Re: Baze-Inoguchi Residence  
Building Permit #2006-188

The following is in response to the Intake Comments CST dated July 21, 2020 for your review.

Re: Baze-Inoguchi

I have reviewed the building department intake comments and made the following revisions in response to these comments.

A0.2

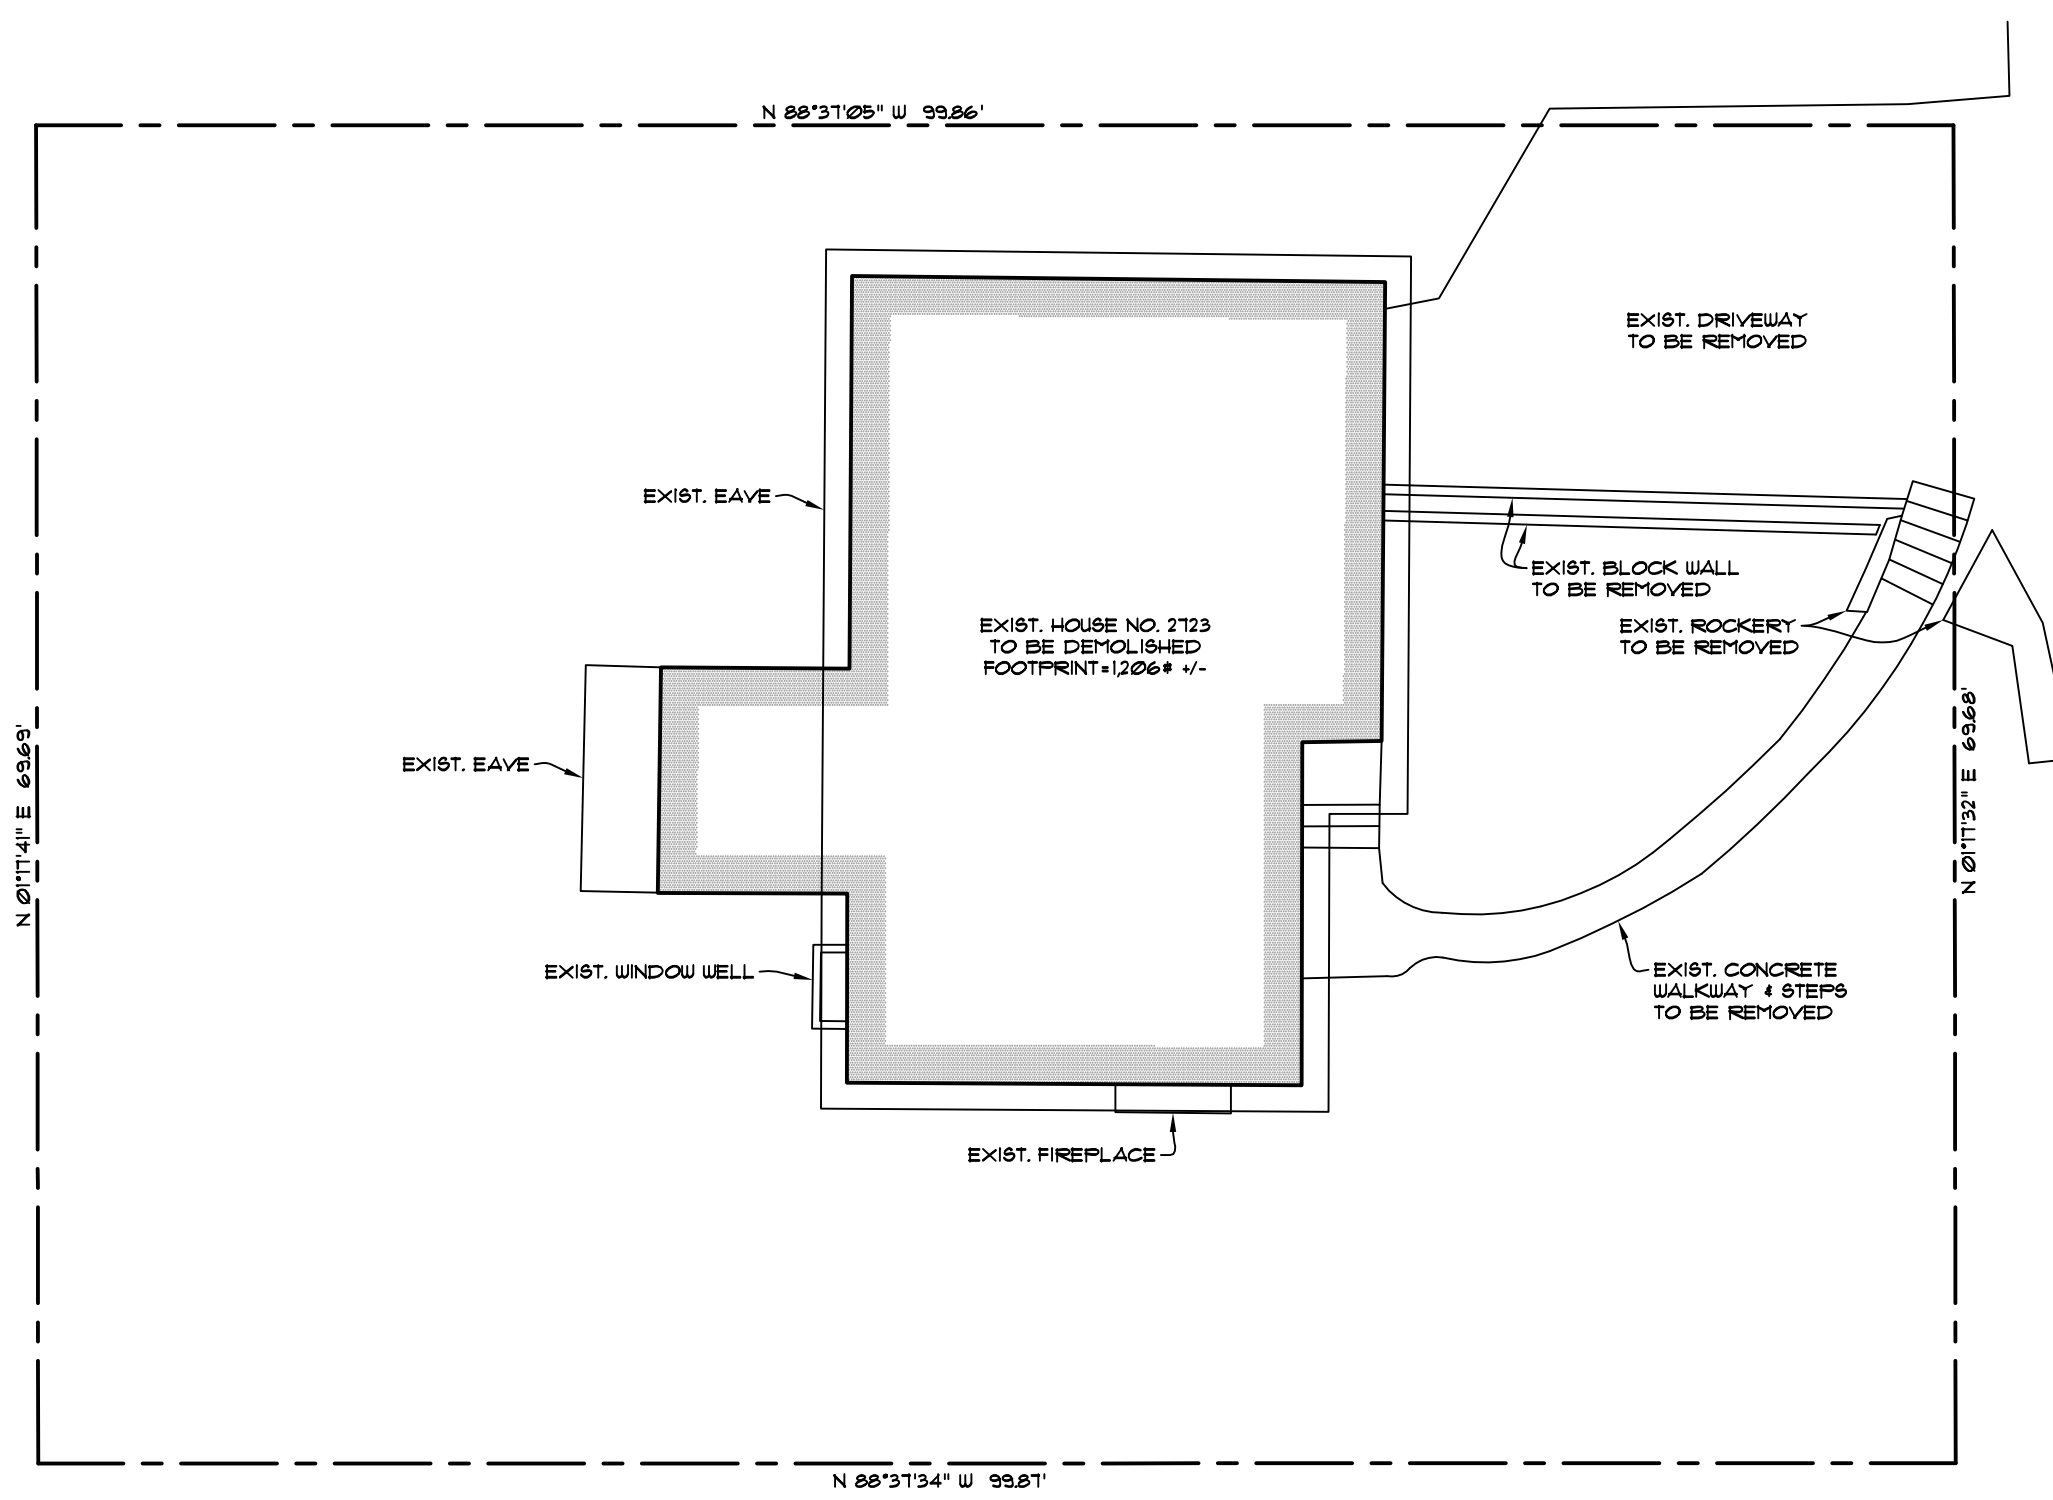
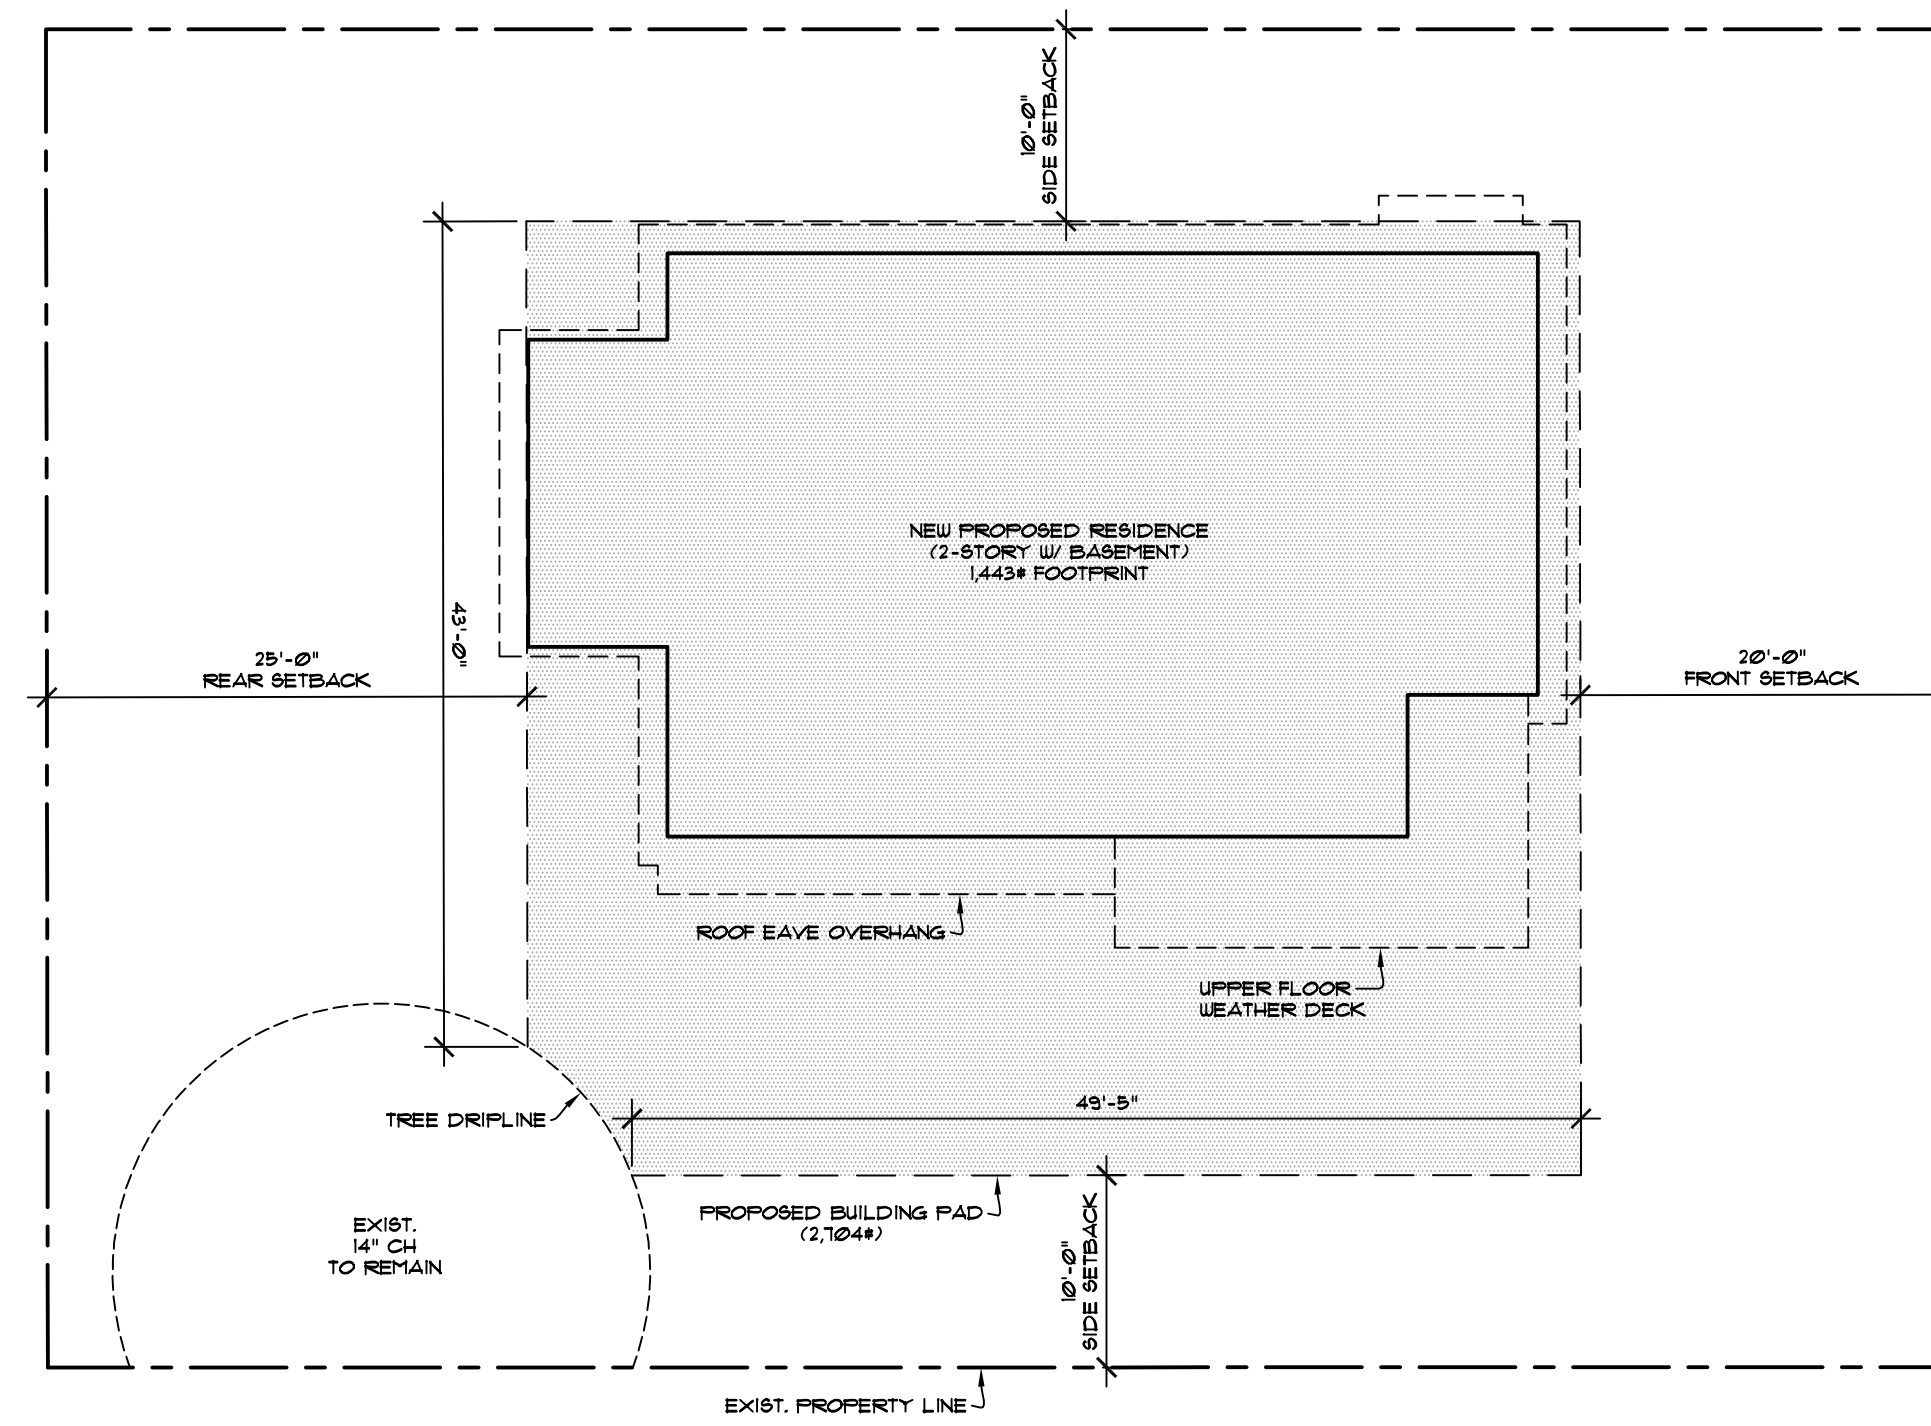
1. Provided legal description.
2. Added driveway length & width.
3. Added building pad area. Sheet A0.2.
4. Added amount of covered & uncovered parking stalls.
